## **OFFICIAL NOTIFICATION OF DECISION**

**Project# PR-2021-005597**  
**Application#**  
**SD-2024-00136 PRELIMINARY/FINAL PLAT**

For all or a portion of: **LOTS 1 thru 10, THE UNIVERSITY OF ALBUQUERQUE URBAN CENTER** zoned **NR-C**, located at **3801 COORS BLVD NW between COORS BLVD and ST JOSEPHS** containing approximately **26.5** acre(s). **(G-11)**

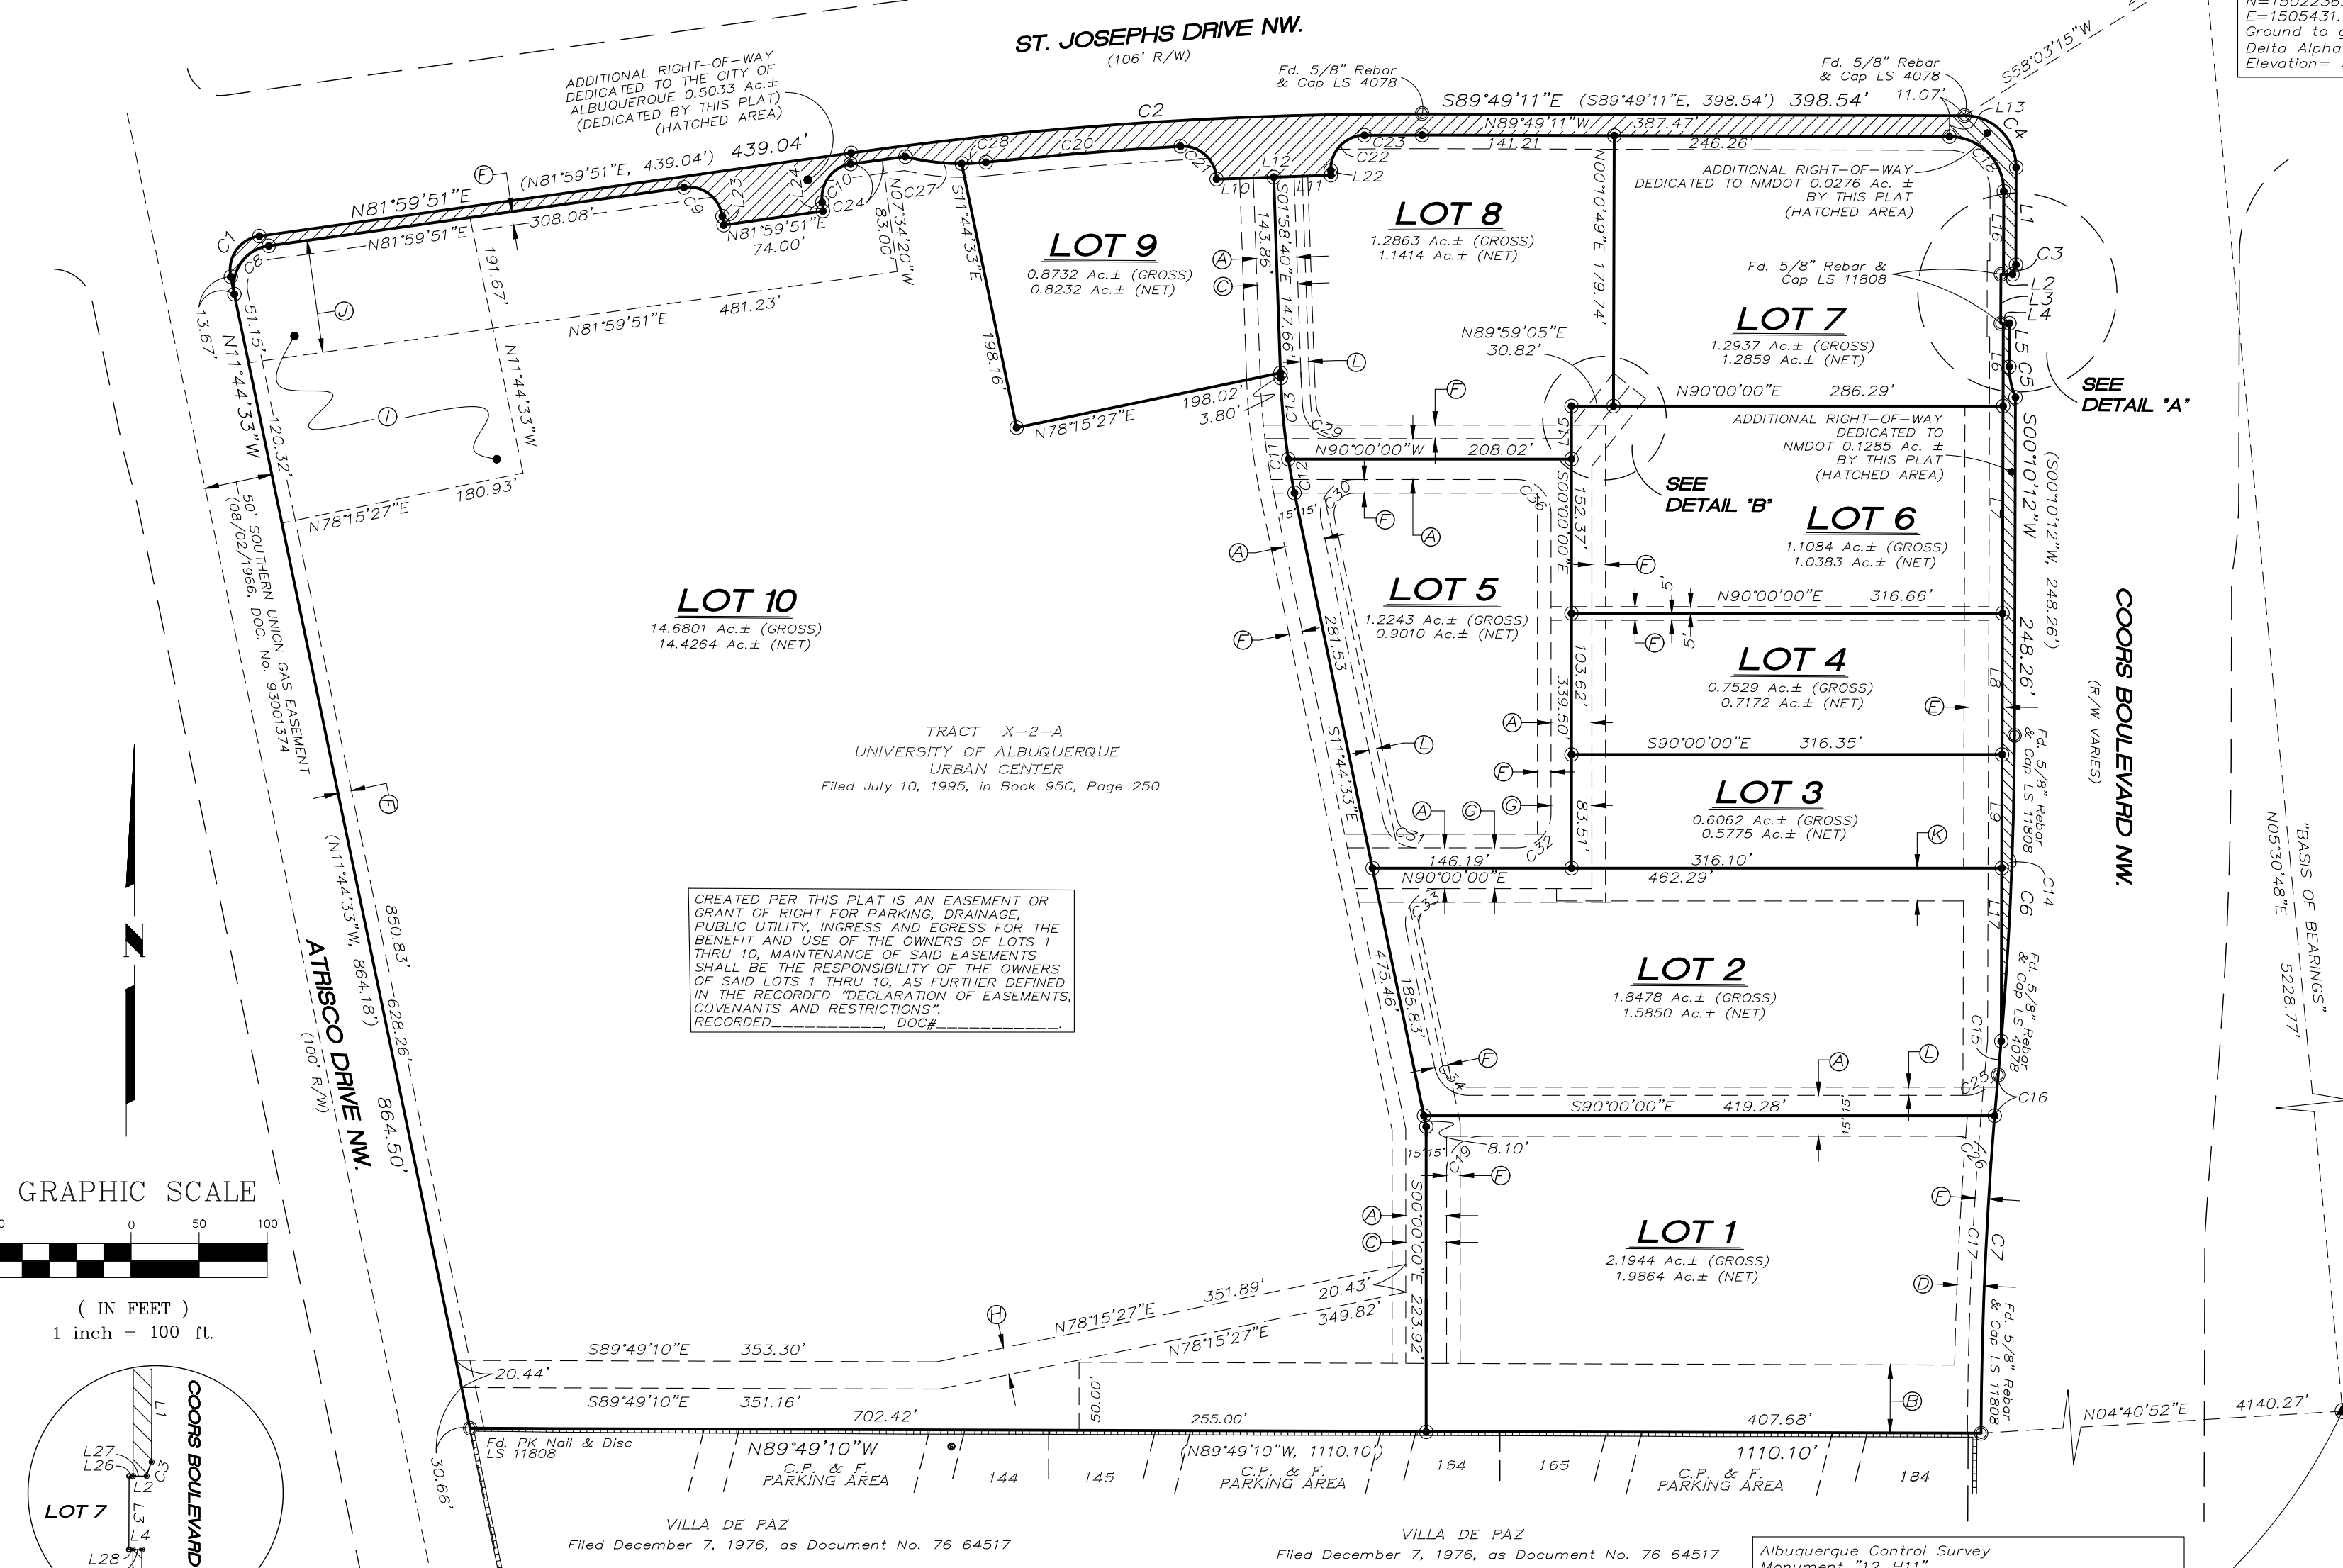
1. This is a request for corrections to Easements A and L on the Final Plat for PR-2021-005597 / SD-2023-00092, which was approved by the DHO on May 10, 2023 and recorded on July 11, 2023, as they were incorrectly labeled as public easements when they should have been labeled as private easements.
2. The subject property is zoned NR-C (Non-Residential Commercial). Future development must be consistent with the underlying zone district and the IDO/DPM.
3. The Applicant satisfied the public notice requirements in compliance with the IDO Table 6-1-1 prior to this submittal.

- a. A clean version of the approved Plat must be submitted, including new signatures from the owner, and City Surveyor, and a new stamp and signature from a licensed surveyor in the State of New Mexico.
- b. Project and application numbers must be added to the Plat.
